Date: 02-Oct-2025  
Our Ref: 2025/92126

**Application for Approval of Details Reserved by Condition  
Town and Country Planning Act 1990  
Planning (Listed Buildings and Conservation Areas) Act 1990**

**Discharge of details reserved by conditions 6 (bin storage), 8 (materials), 10 (bat box), 11 (electric vehicle recharging) on previous permission 2020/91456 for erection of detached dwelling  
adj, 7, East Street, Jackson Bridge, Holmfirth, HD9 1HY  
Application Number: 2025/92126**

Drawing Number\_  
 24\_809 121

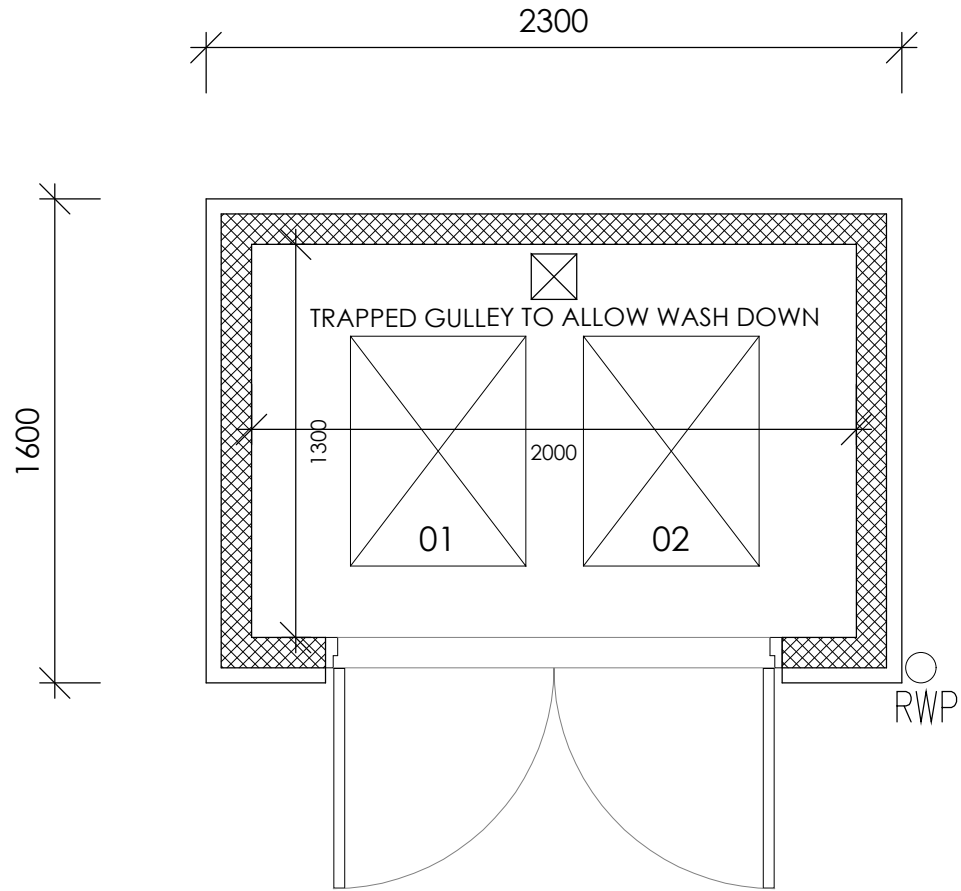
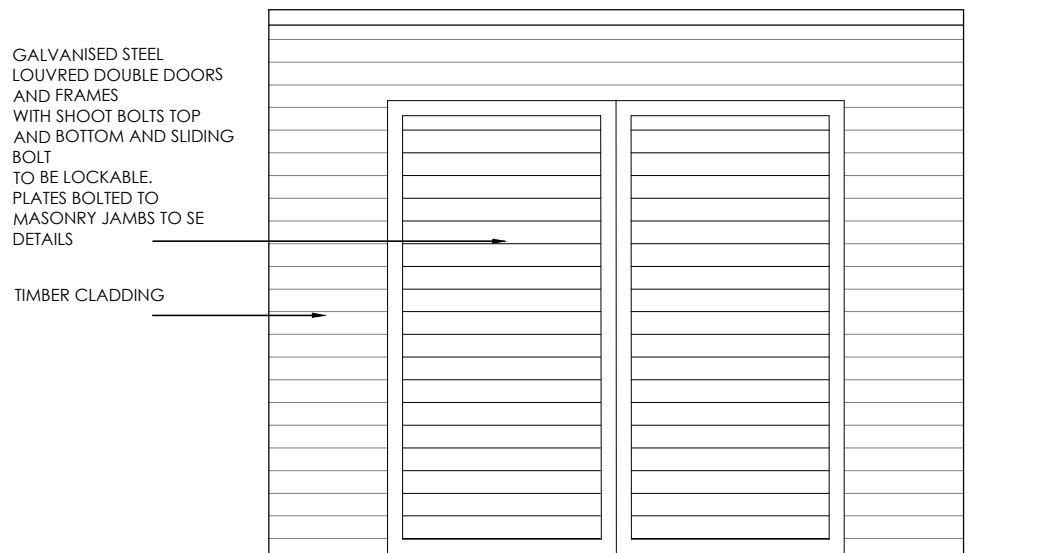
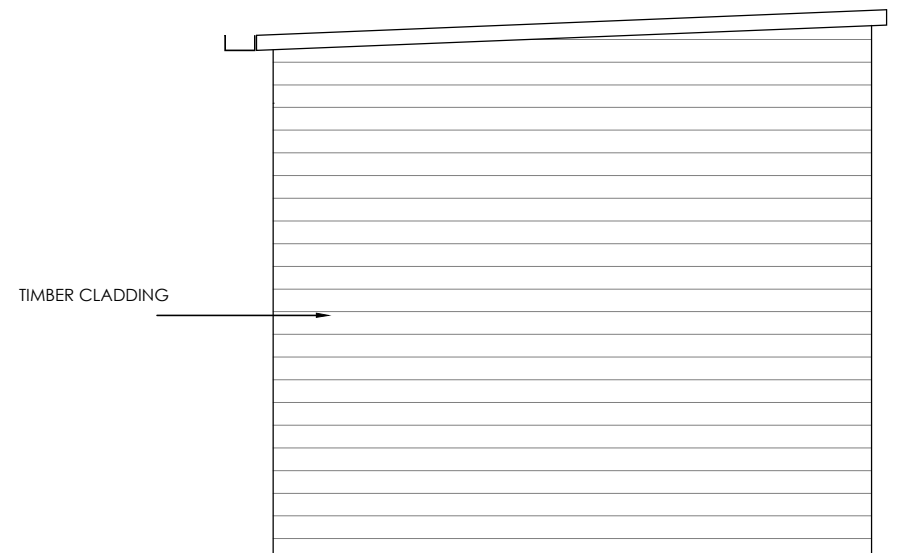
Site plan reference 24\_809 120 has been submitted showing the bin storage and presentation points and bin store details on 24\_809 121. The details are not acceptable and as such Condition 6 cannot be discharged. A new application addressing the concerns outlined should be submitted.
